Application Reference: EN010151

Submitted by: LCJ Mountain Farms Ltd (Interested Party Ref: F8D0BCE95)

Document: Response to Applicant Responses to relevant Representations [RR-026]

Deadline: Deadline 2 – 21 October 2025

ExD2.1 – LWS 4722: Applicant Corridor Adjacency & Construction Compound Offset

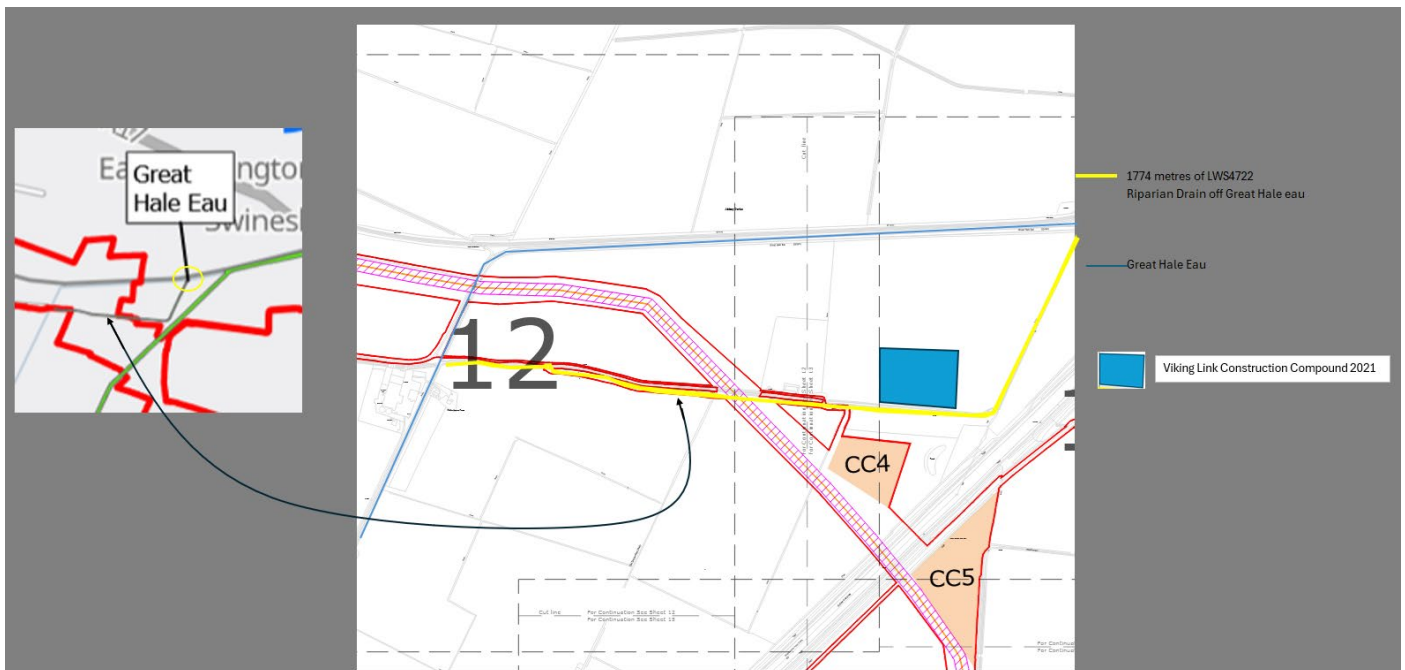
- Applicant’s preferred corridor runs longitudinally for approximately 1.19 km directly adjacent to LWS 4722, with Construction Compound 4 located just 70 m away (ExD2.1). LWS 4722 is hydrologically linked to a 7.20 acre woodland block and includes 0.43 ha of AB1 Nectar Flower Mix under LCJMF’s Countryside Stewardship Agreement, forming a continuous ecological corridor (ExD2.2). This corridor would experience sustained longitudinal disturbance during construction and operation due to the 45° alignment of the 30 m trenching corridor and separate haul road.
- LCJMF hybrid route avoids this corridor entirely. It involves a single perpendicular crossing of Old Forty Foot Drain (LWS 4490), maintains a 177 m stand-off from Willow Farm Drain (LWS 4520), and a 262 m stand-off from Mill Drain (LWS 4489).

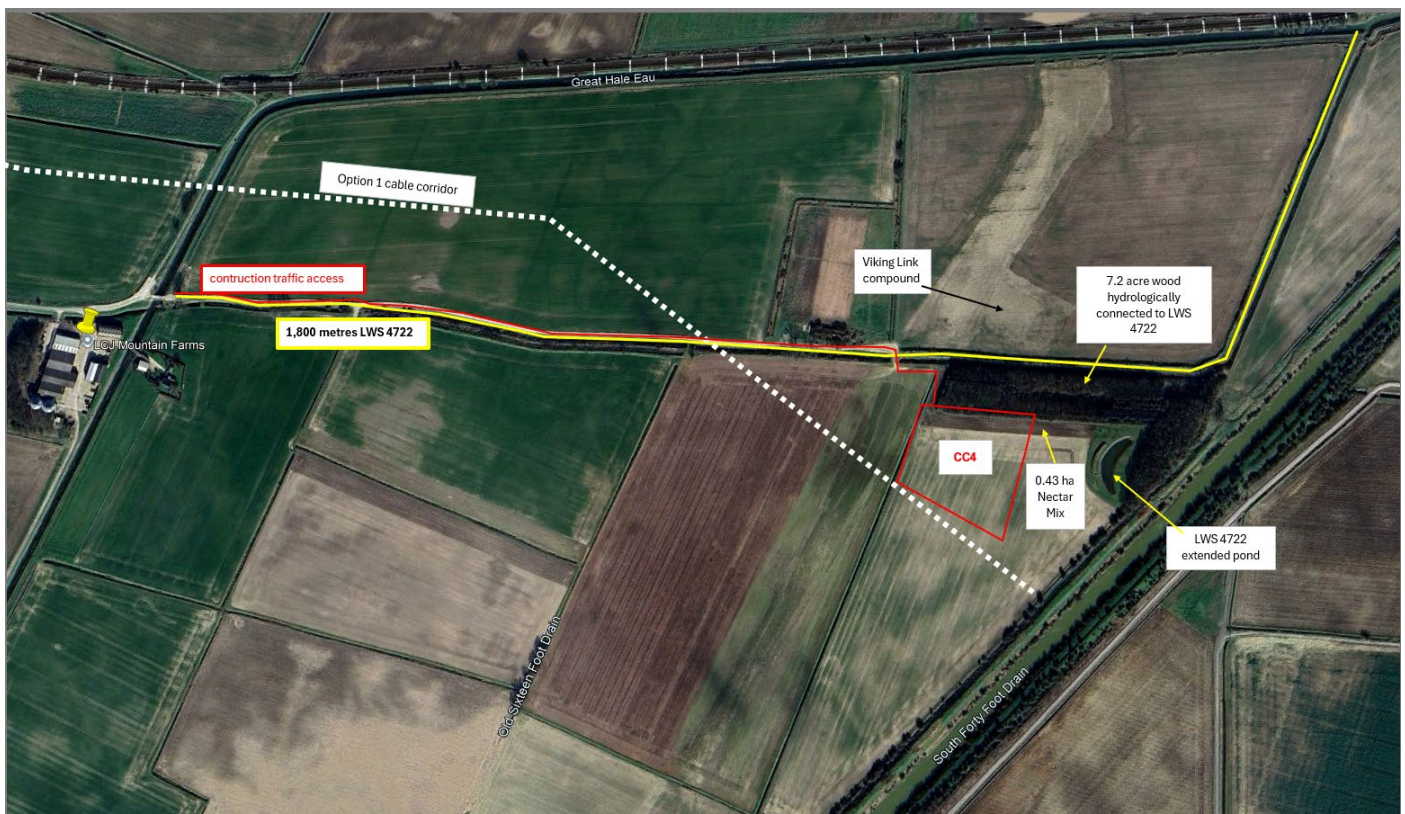
The Applicant’s 30 m cable working corridor intersects LWS 4722 at approximately 45° — at the same location as Viking Link — while a separate haul road runs longitudinally for ~1 km along its eastern edge, serving Construction Compound 4 (ExD2.2). Over such distances, longitudinal interfaces can cause equal or greater disturbance than perpendicular crossings. No ecological evidence supports the Applicant’s claim that adjacency (CC4 at 70 m) is less significant than LCJMF’s hybrid stand-offs of 177 m and 274 m from Willow Farm and Mill Drains (ExD2.3).

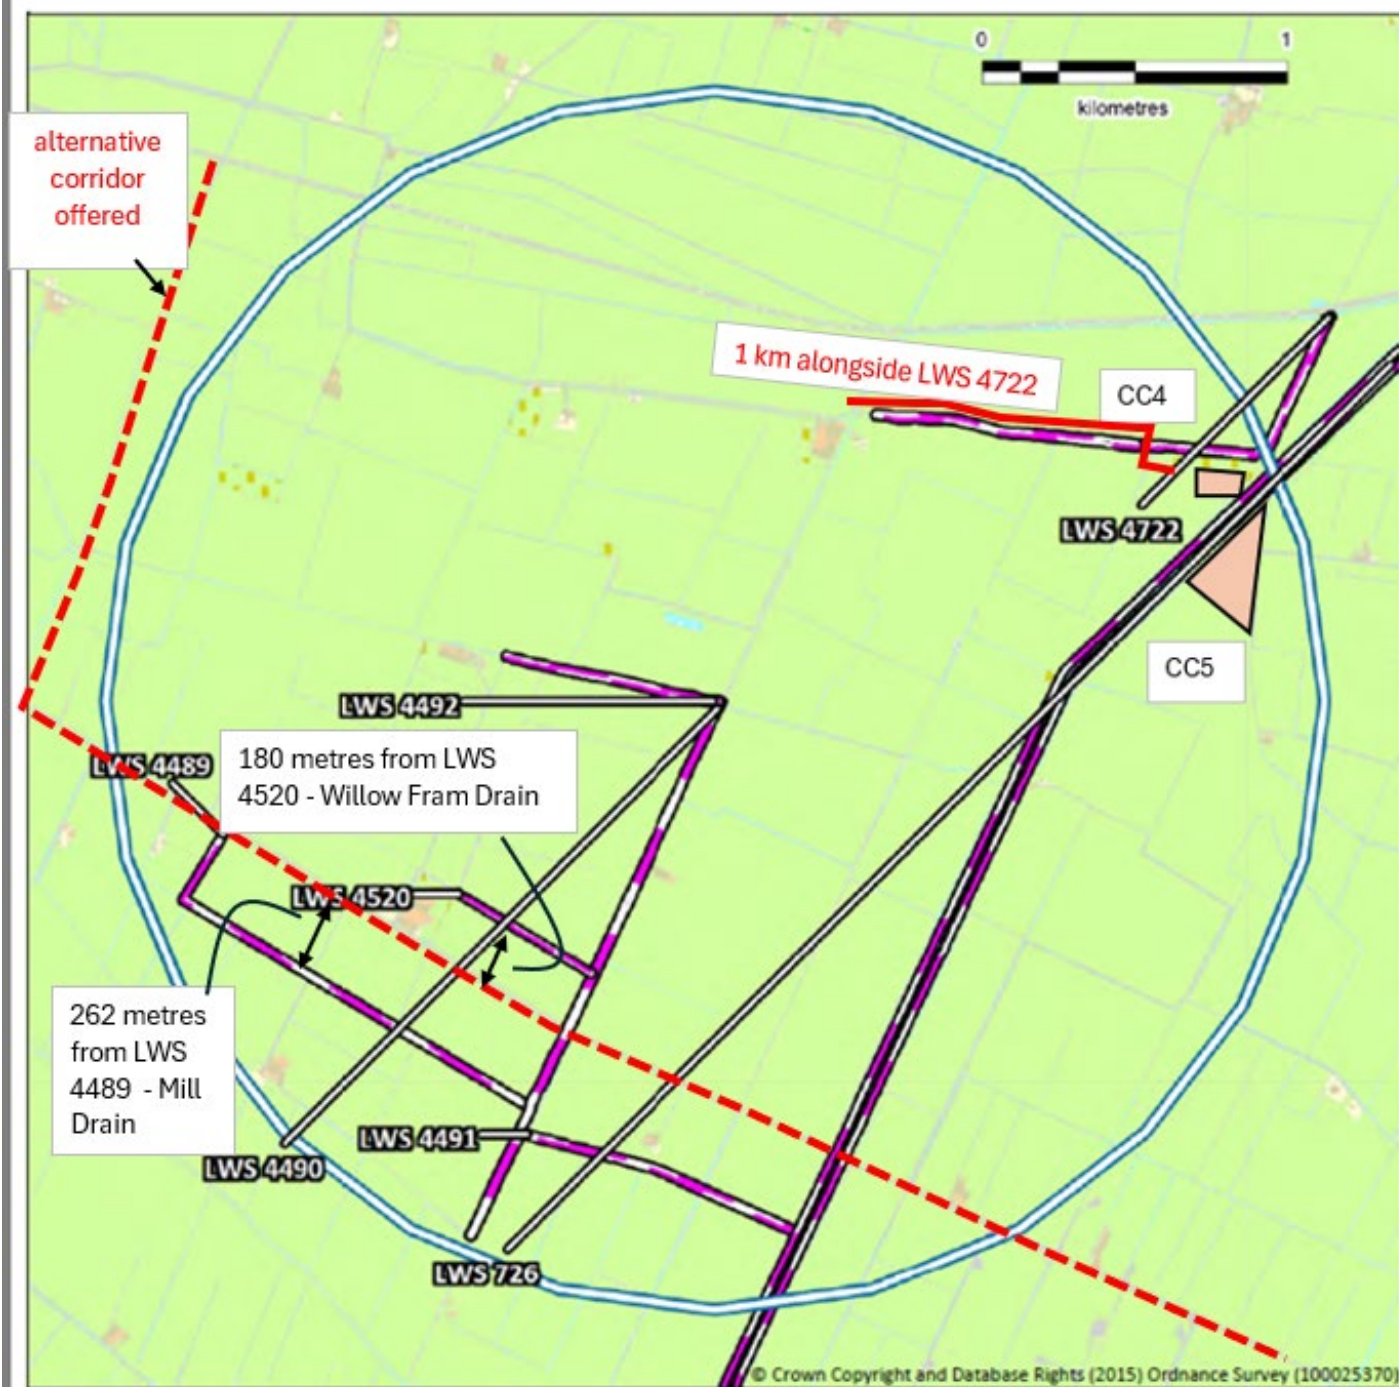
As shown in ExD2.3, the Applicant’s alignment creates a prolonged ecological interface with LWS 4722, whereas the LCJMF hybrid alignment maintains wide hydrological and ecological buffers and involves only one perpendicular crossing. The Applicant has not produced a like-for-like ecological comparison of these options, contrary to EN-1 § 4.4.3 and Reg. 14(2)(d). Its conclusion that the LCJMF route would have “greater impact” is therefore unsupported.

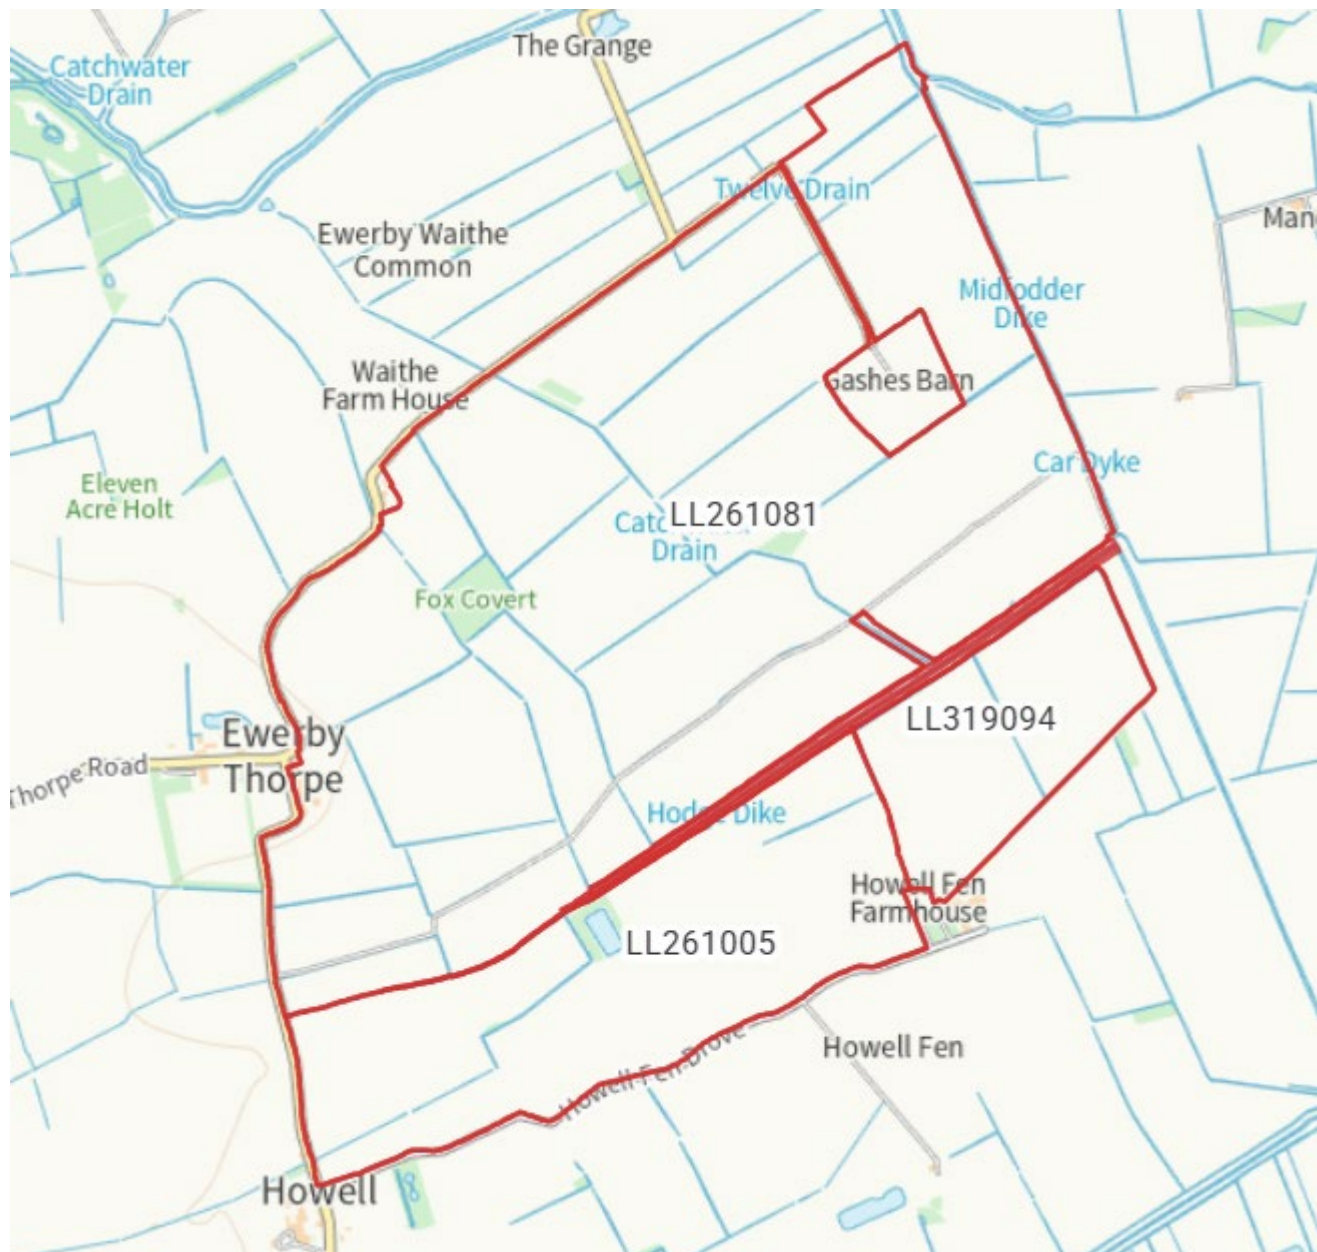
- Potential net reduction in agreements: Siting PV/BESS on LCJMF’s land could have consolidated the generation site, cable route, and access corridors within a single ownership block, simplifying land assembly compared to Beacon Fen North, which spans three ownerships (LL261089, LL319094, LL261005). LCJMF’s August 2023 offer of 618 acres exceeds the combined area of LL261005 (240 acres) and LL319094 (110 acres) (ExD2.9).

ExD2.9 – Viking Link Pipeline: Before-and-After Soil Structure Survey (2021–2023), LCJ Mountain Farms Ltd

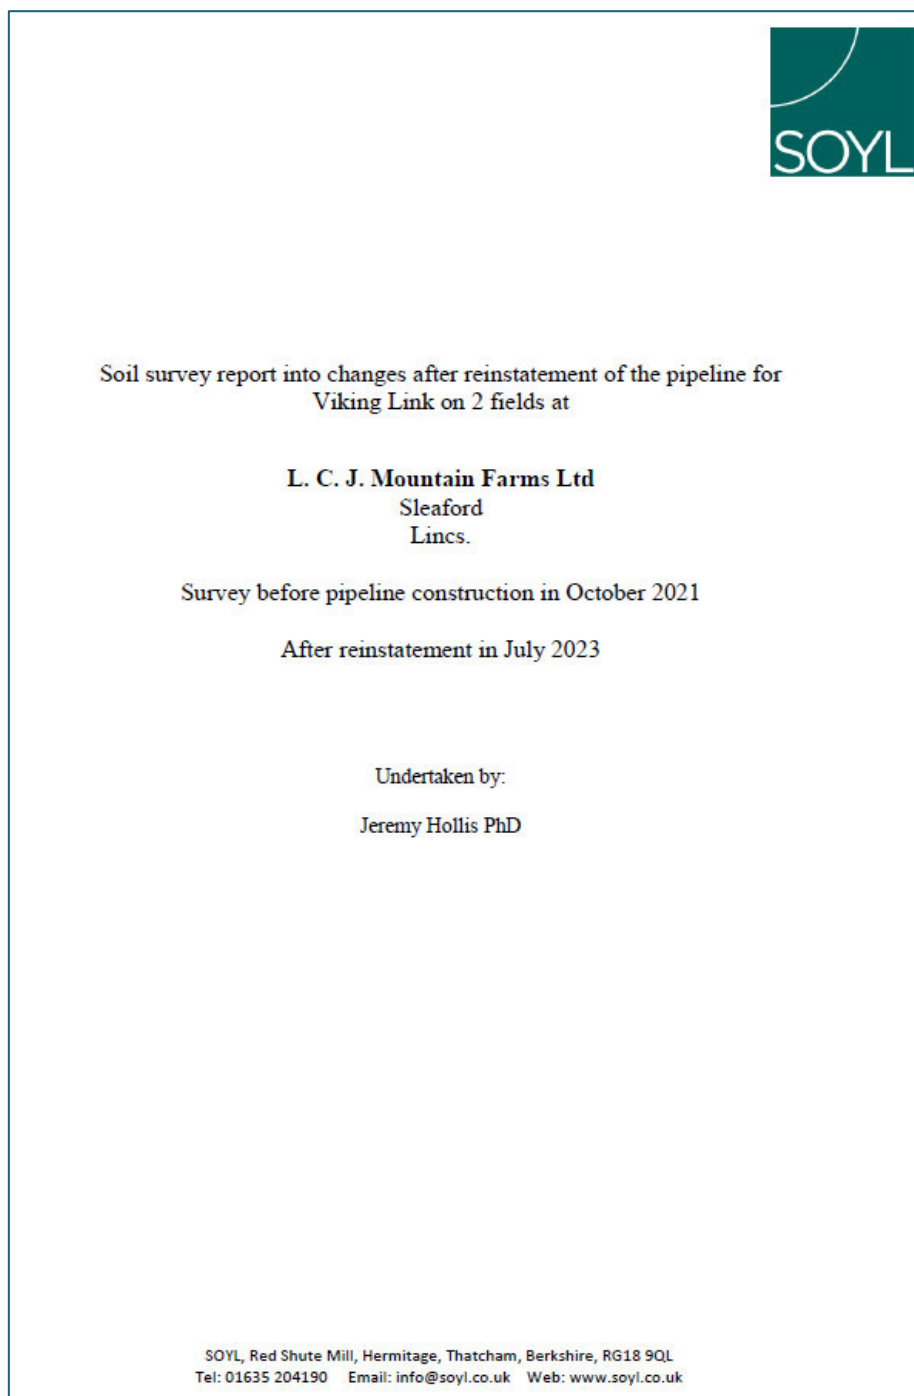
To assess real impacts, LCJMF commissioned before-and-after soil surveys from SOYL Ltd (Dr Jeremy Hollis PhD). Baseline surveys were taken in October 2021; post-construction surveys in July 2023 (ExD2.9). Key findings:

- Topsoil and subsoil remained broadly in place, but topsoil structure deteriorated significantly.
- In 2021, only the heaviest soil type showed poor structure; by 2023, 5/7 assessment points were rated “poor”, none “good”.
- Heavier, higher-conductivity soils showed the greatest deterioration.

This is direct empirical evidence from the same landholding, the same 1.2 metre deep cable laying construction method and even in the same affected field. It shows that reinstatement does not fully restore soil structure, and impacts persist beyond construction. The Applicant’s failure to reference or assess this precedent undermines its claim of a “robust” assessment and exposes the limitations of relying on post-consent, generic OSMPs.
